**Re: Security Fire Station No. 4 – 7600 Wayfarer Drive (PPR-20-029, CON-22-028)**  
**Engineer's Punch List Response**  
**M.V.E. Project No. 61134**

This letter is the engineer's response to Preliminary Acceptance Punchlist issued for the project on 5/24/2023. Responses, if any, are in bold type.

**ASBUILT - 8/21/2023**  
 REG EURV = 0.061 ACFT. / ASBUILT = 0.082 ACFT.  
 REG 100YR = 0.103 ACFT. / ASBUILT = 0.106 ACFT.

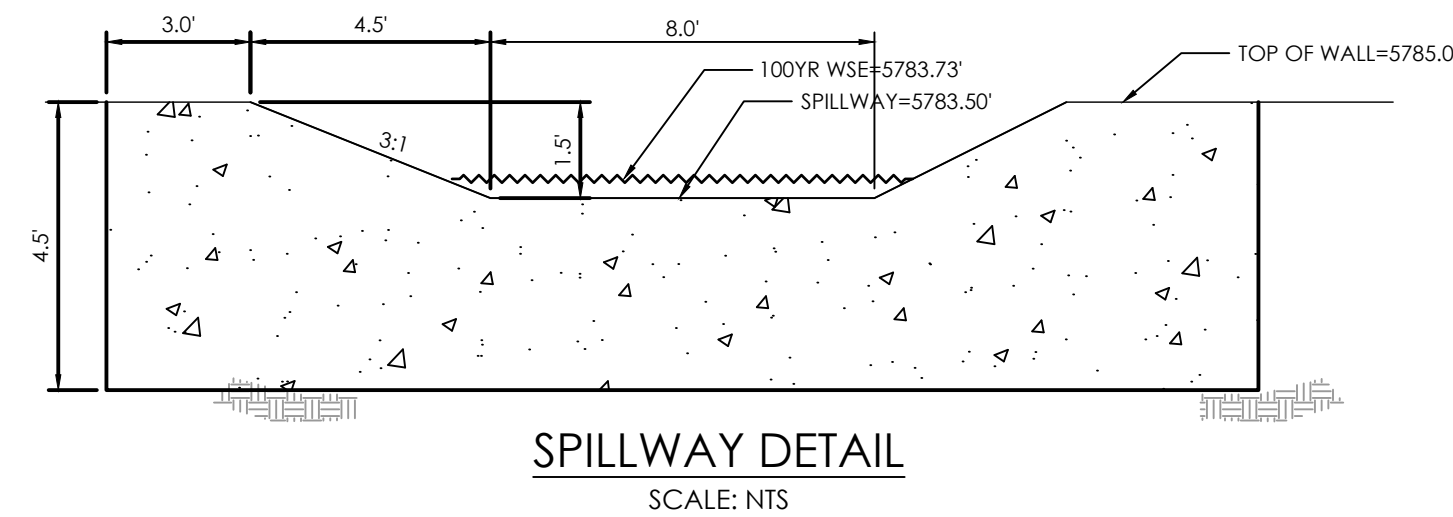
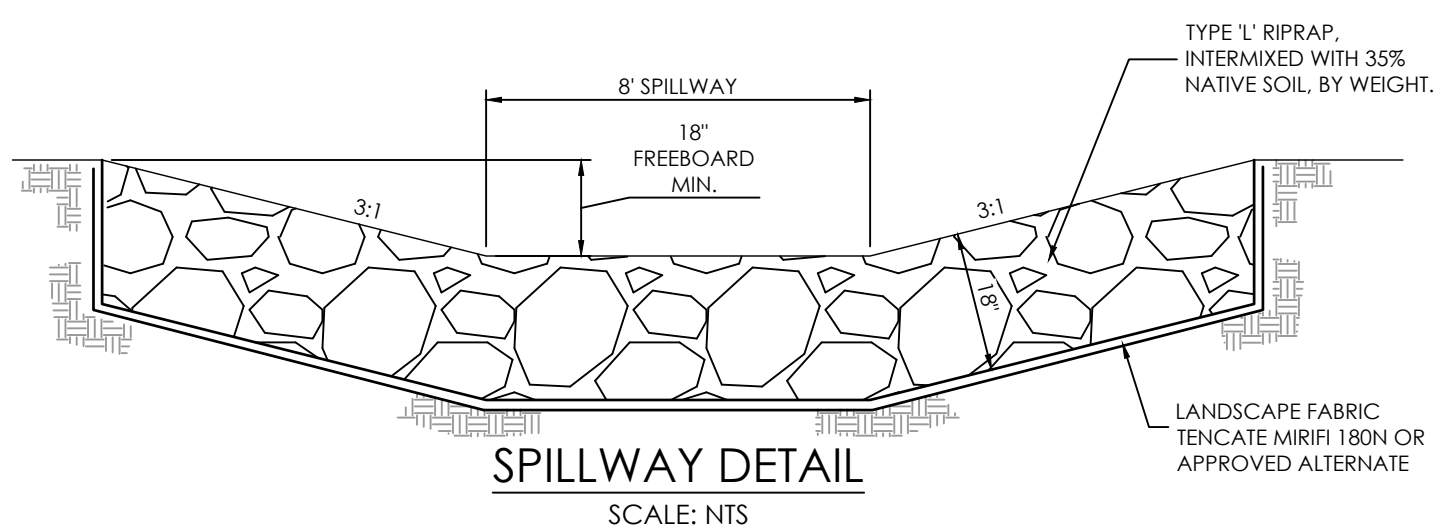
- Undercutting occurring at riprap rundown at southeast corner of pond – **Engineer requested that the voids in rip-rap be filled with 3/4" to 3" rock to protect fine material beneath the larger riprap rock.**
- Area drain at north east corner requires re-grading to promote positive drainage. - **The area drain and grading at the northeast corner of the building are observed to be installed according to the plan functioning as intended with positive drainage to the inlet and away from the building. No changes are necessary.**

- Space between microscreen and orifice plate is not enclosed as shown on plans. This is a maintenance concern. In the field we discussed potentially bolting on a metal plate to cover the gap. Discuss options with project engineer. - **Contractor agreed to install a plate to close off the referenced gap.**

- Section A-A shows the dimension from the invert of the underdrain to the bottom of the orifice plate at 30". However, the field measurement was closer to 34". Make sure that this difference is reflected on the as-built plans and on the updated UD-Detention spreadsheet, because that may have affected the elevation of the orifice holes. - **The invert of the underdrain at the box interface was constructed 0.20' lower than the elevation shown on Section A-A. The elevation of the three orifice holes in the orifice plate are within survey tolerance of the design elevations shown on the plan. The as-built drawing indicates the as-built elevations. Top of box elevation, and spillway crest elevation is also located within survey tolerance of**

• Similar comment for the invert of the outlet pipe: Section A-A shows the invert of the outlet pipe to be elevated 1-5/8" above the bottom of the outlet structure. But it was instead installed flush with the bottom. Reflect on as-built drawings and calcs. - **The elimination of the 1 5/8" gap for the outlet pipe is shown on the As-Built and included on the updated UD-Detention Worksheet. No significant changes to the pond operation result.**

**the design elevations. The UD-Detention Worksheet has been updated to reflect the revised underdrain outlet elevation which slightly decreases drain times of the EURV and 2-yr storm by one hour, but remains within state requirements for drain times. There is no need to update the SDI for this pond.**
